Application no: **3/2019/0439**

Address: **Land off Easington Road Cow Ark BB7 3DH**

Proposal: **Forestry access track**

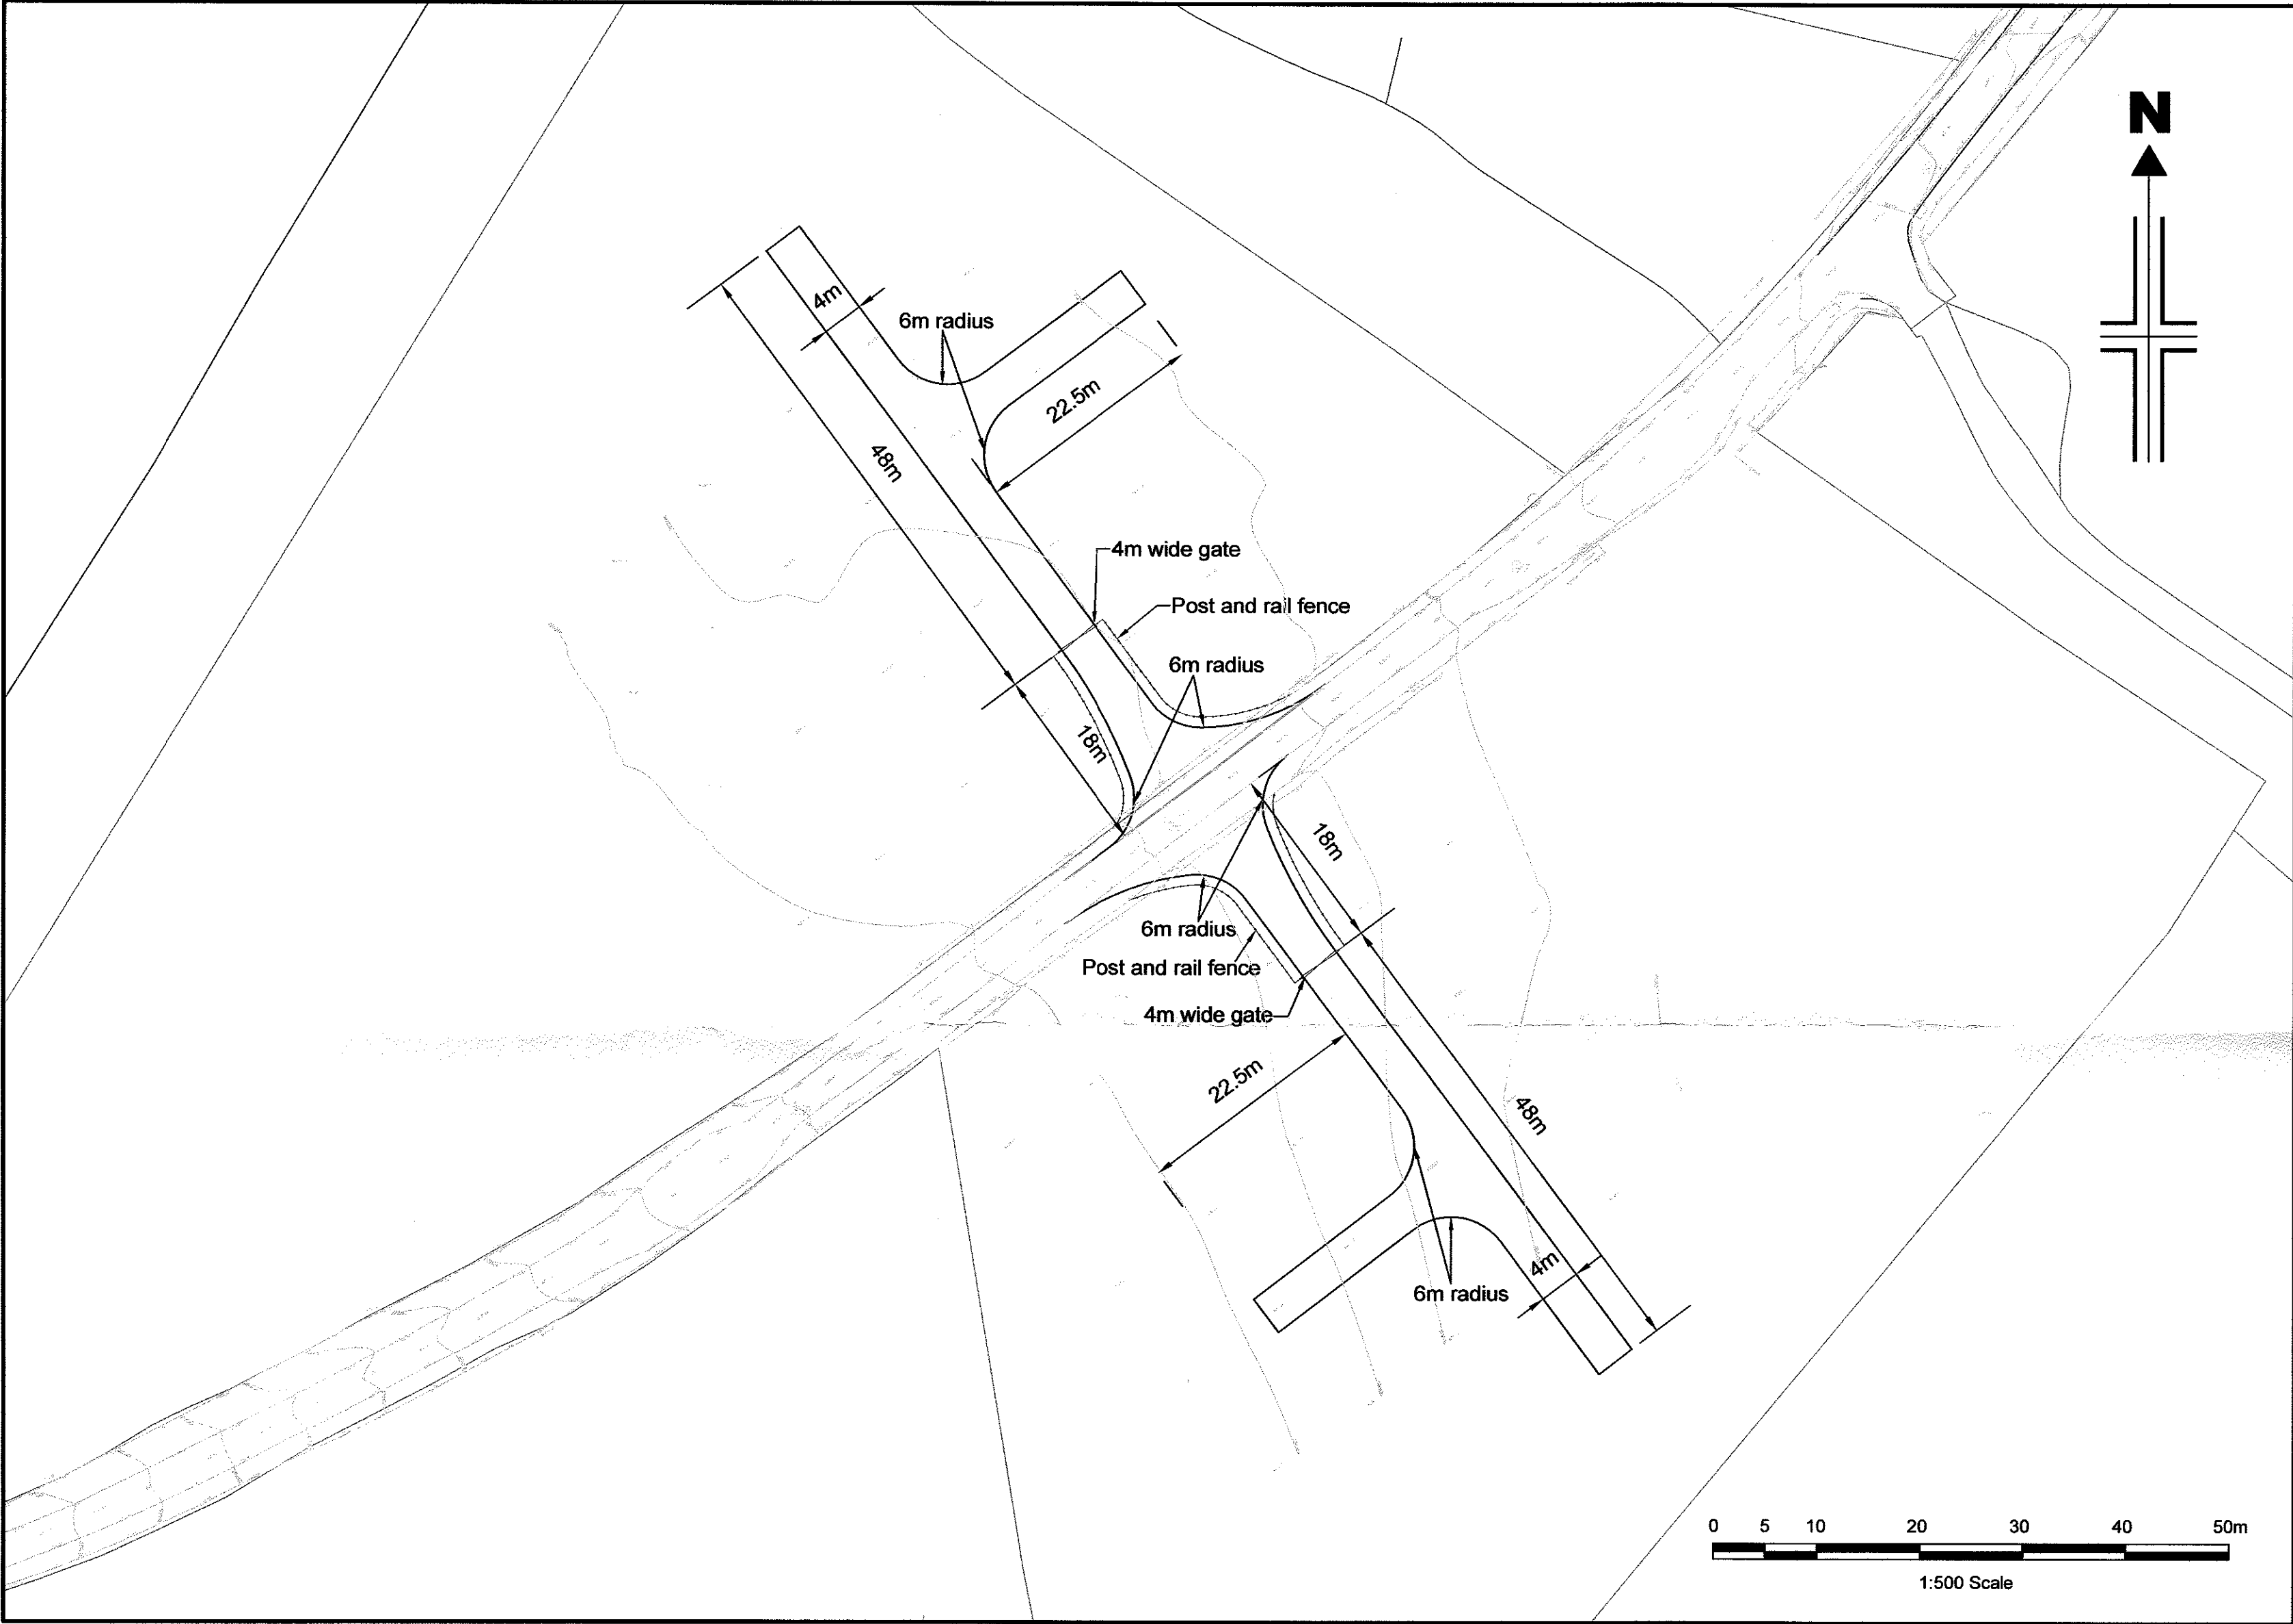
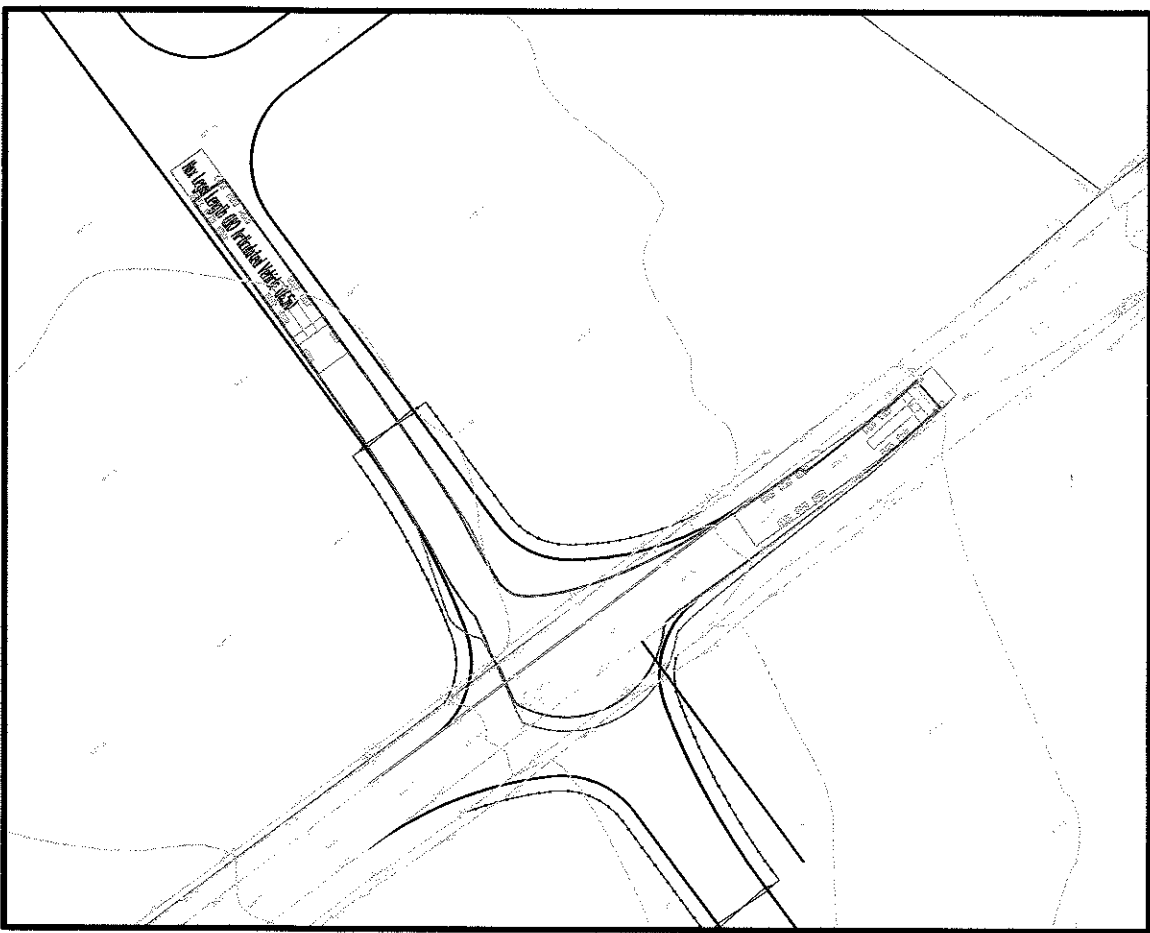
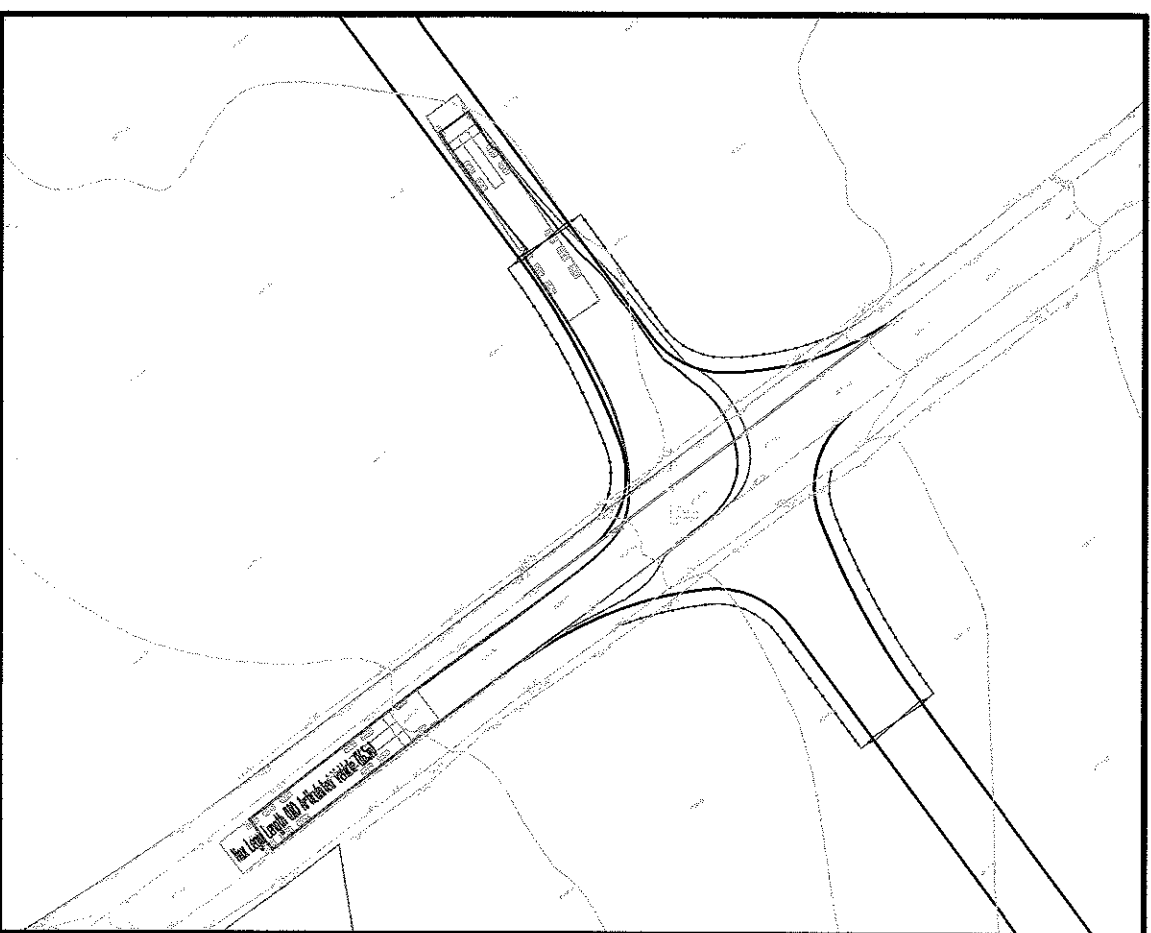
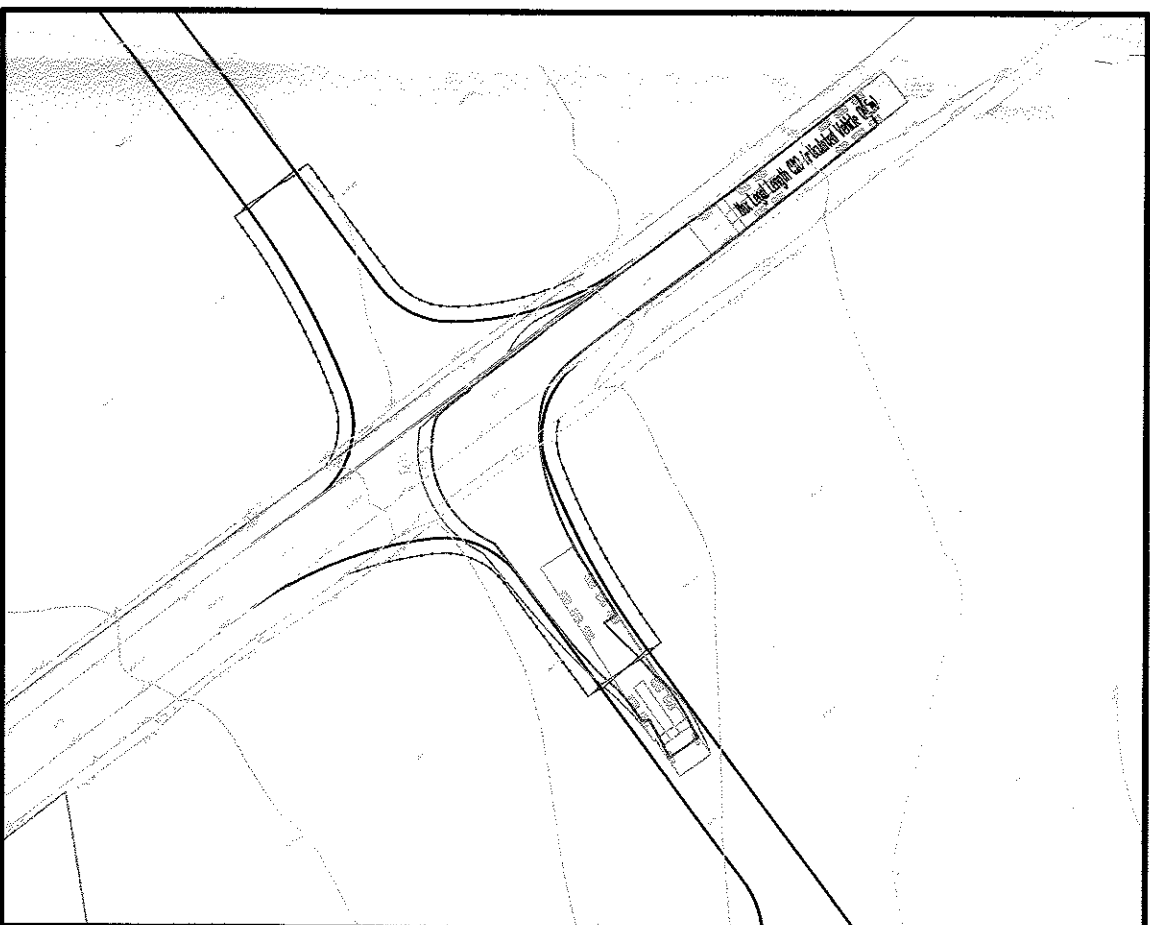
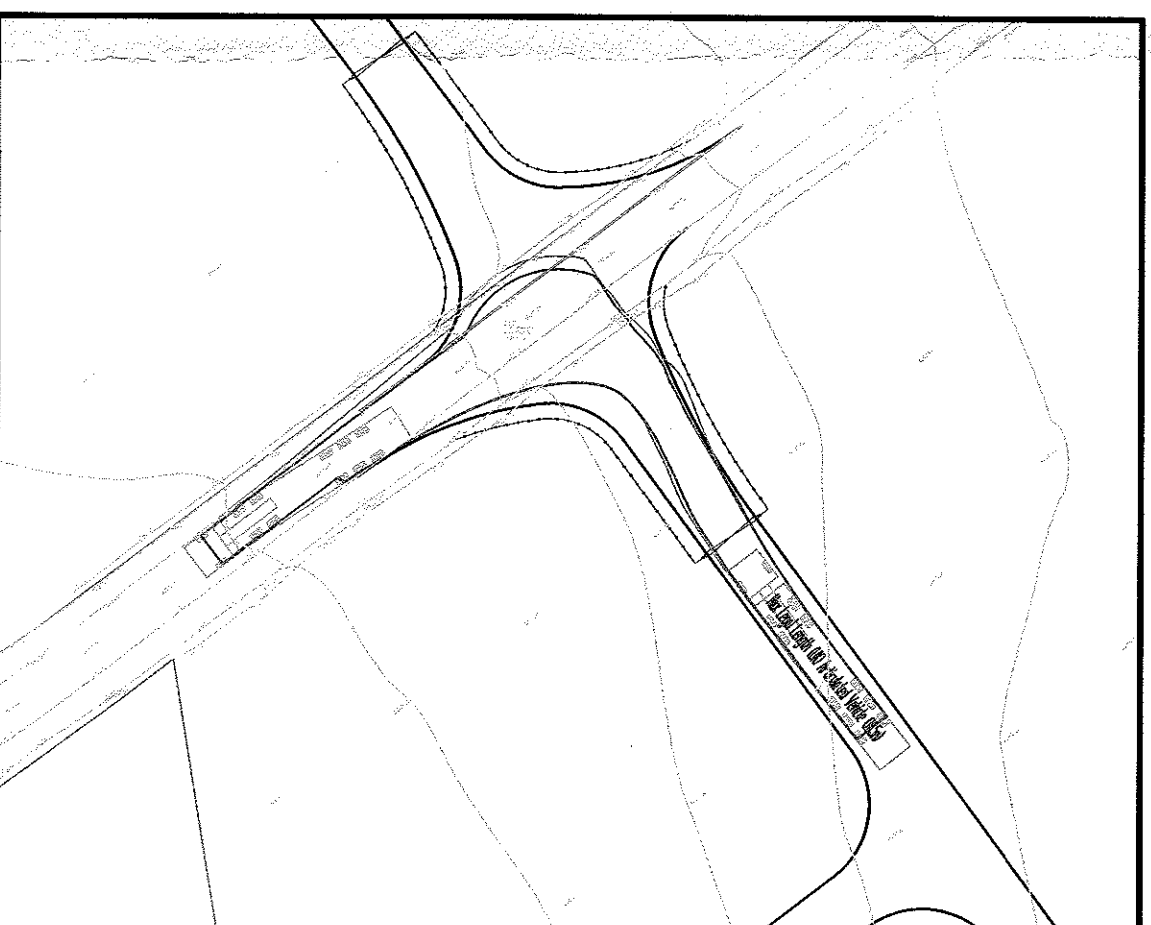
In accordance with drawing number A3038/H-01, it is proposed that two access points are to be constructed for forestry access, with swept path analysis undertaken at both of the access points for articulated vehicles.

Cow Ark Road is an unclassified adopted highway namely U8952 which is subject to the national speed limit. Therefore the construction of the proposed access points will need to be carried out under Section 278 of the Highways Act 1980.

Visibility splays at the proposed access points will need to be demonstrated within the submitted plans. However, it would appear that the required visibility splays for a 60mph road may not be achievable at the proposed access points. I would therefore recommend that an automatic traffic count is carried out in order to demonstrate the 85th percentile speed of passing vehicular traffic within close proximity of the proposed access points on Cow Ark Road.

There has been no indication within the submitted plans as to whether there would be a requirement for any parking provision associated with the proposal.

With respect to the proposal, the application as submitted seeks planning permission for forestry access tracks. However, the Local Highway Authority would require clarification as to the intended purpose of the proposal and any expected vehicular traffic movements that would likely be generated as a result of the proposal.

I ask the plans be revised.
